**MASTER DEVELOPMENT DRAINAGE REPORT
FOR
MEADOWLAKE RANCH
SKETCH PLAN
SKP-18-004**

MARCH 2019

Prepared by:
TERRA NOVA ENGINEERING, INC
721 S. 23RD STREET
COLORADO SPRINGS, CO 80904
(719) 635-6422

SKETCH PLAN

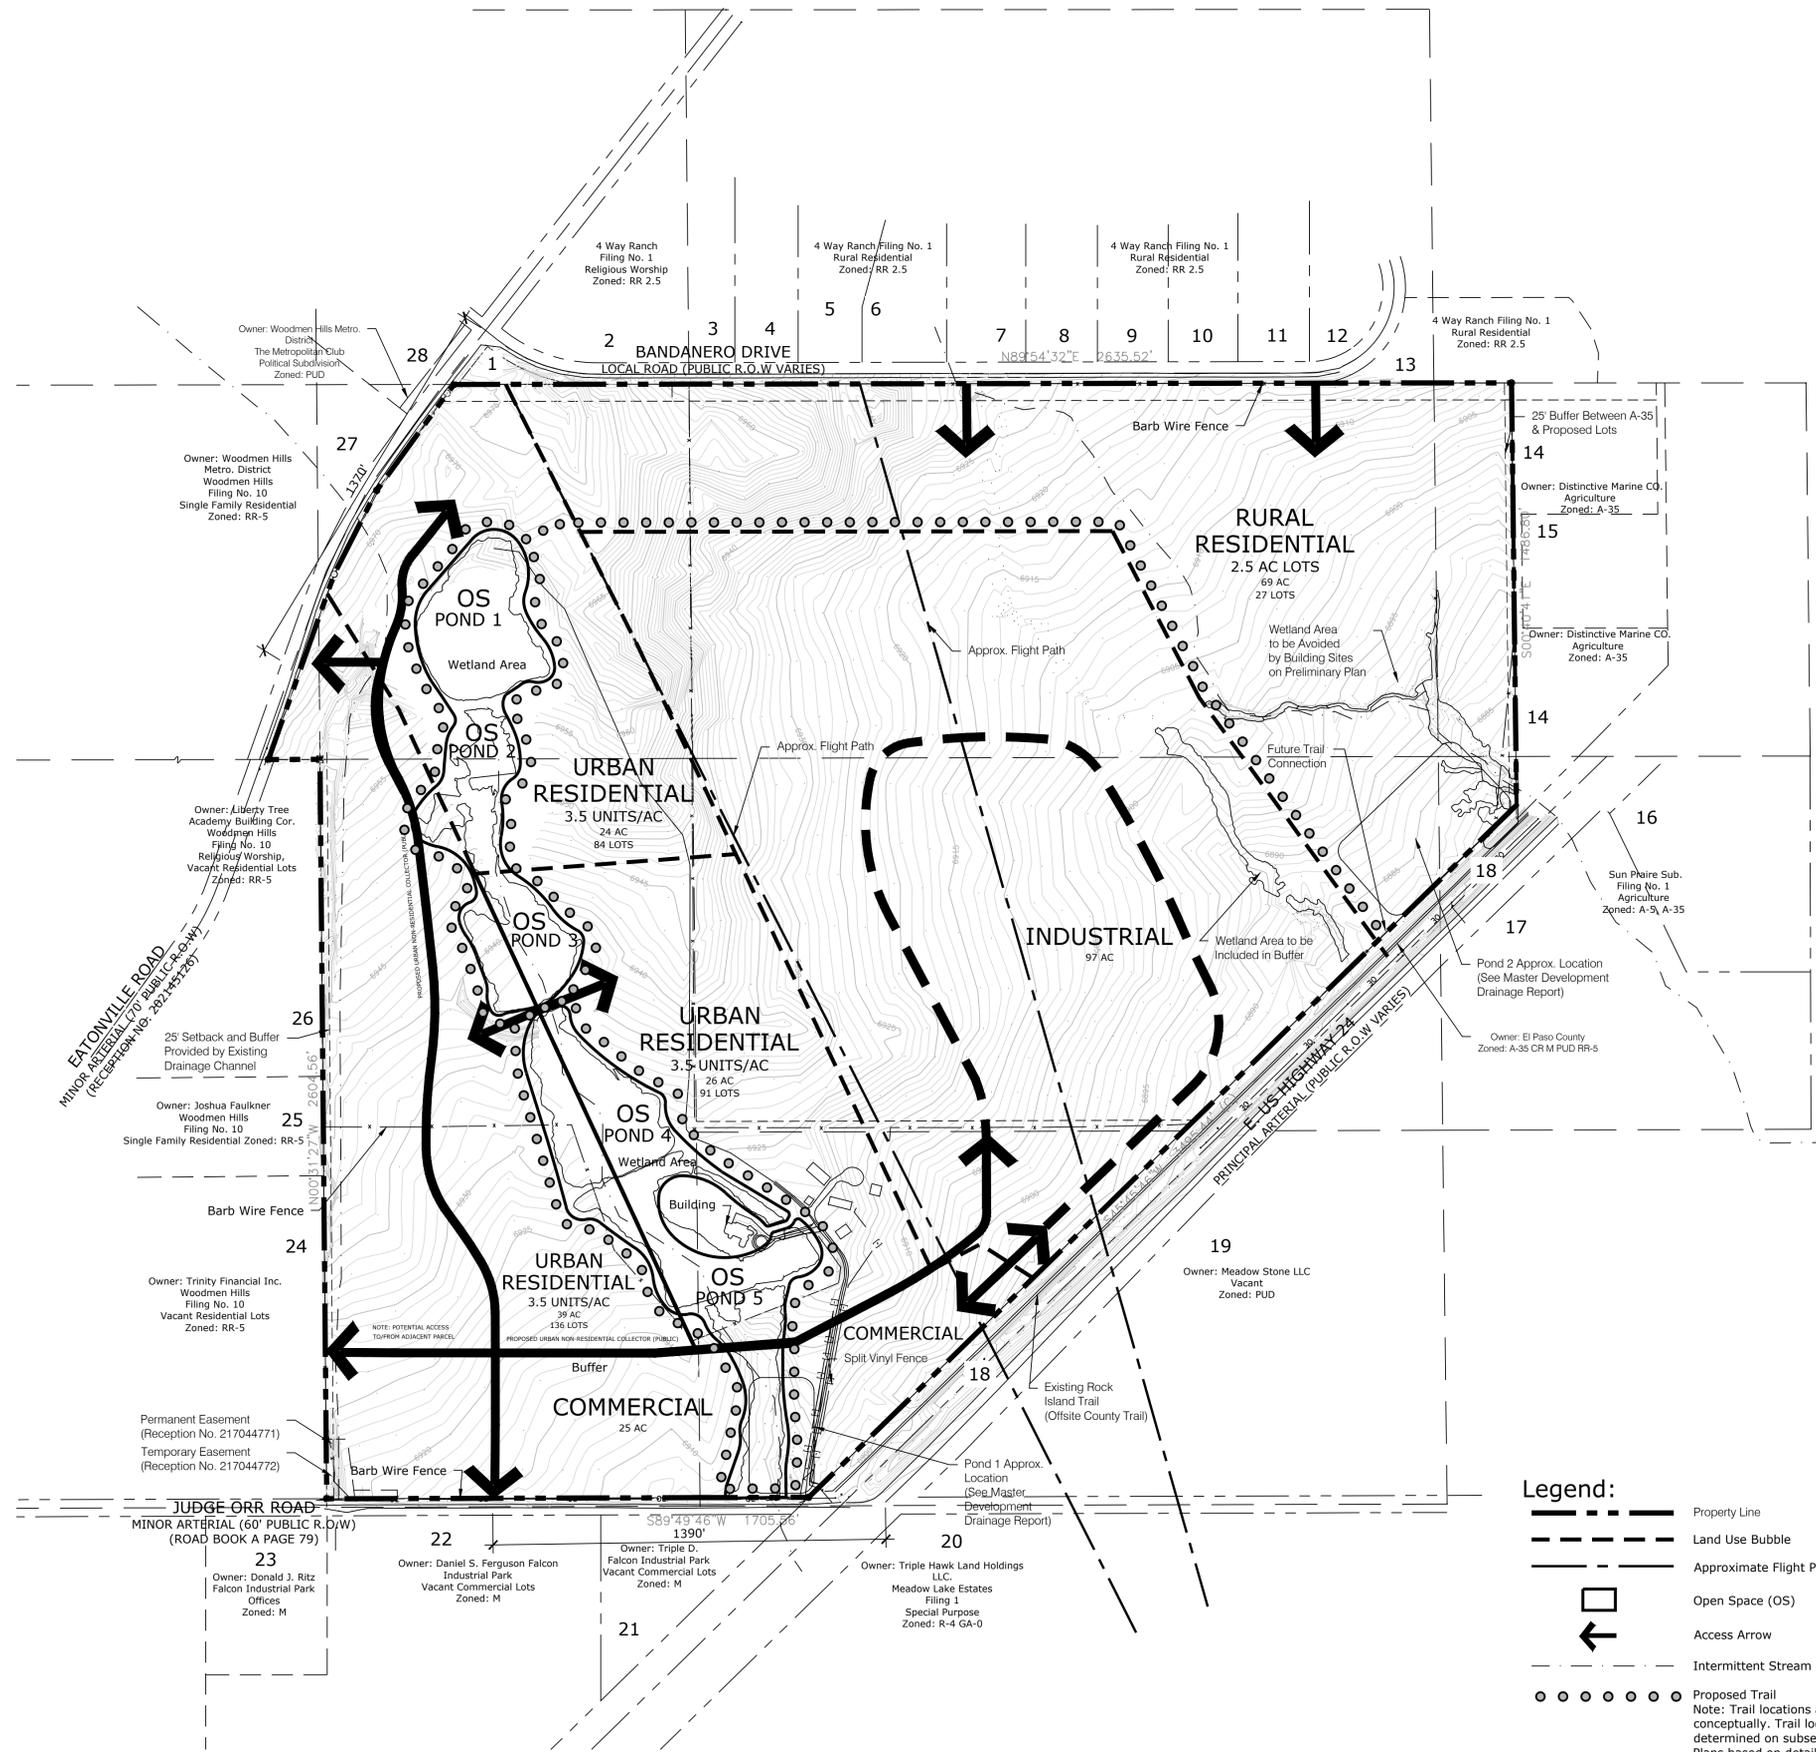
Include acreage of the overall site included in the sketch plan
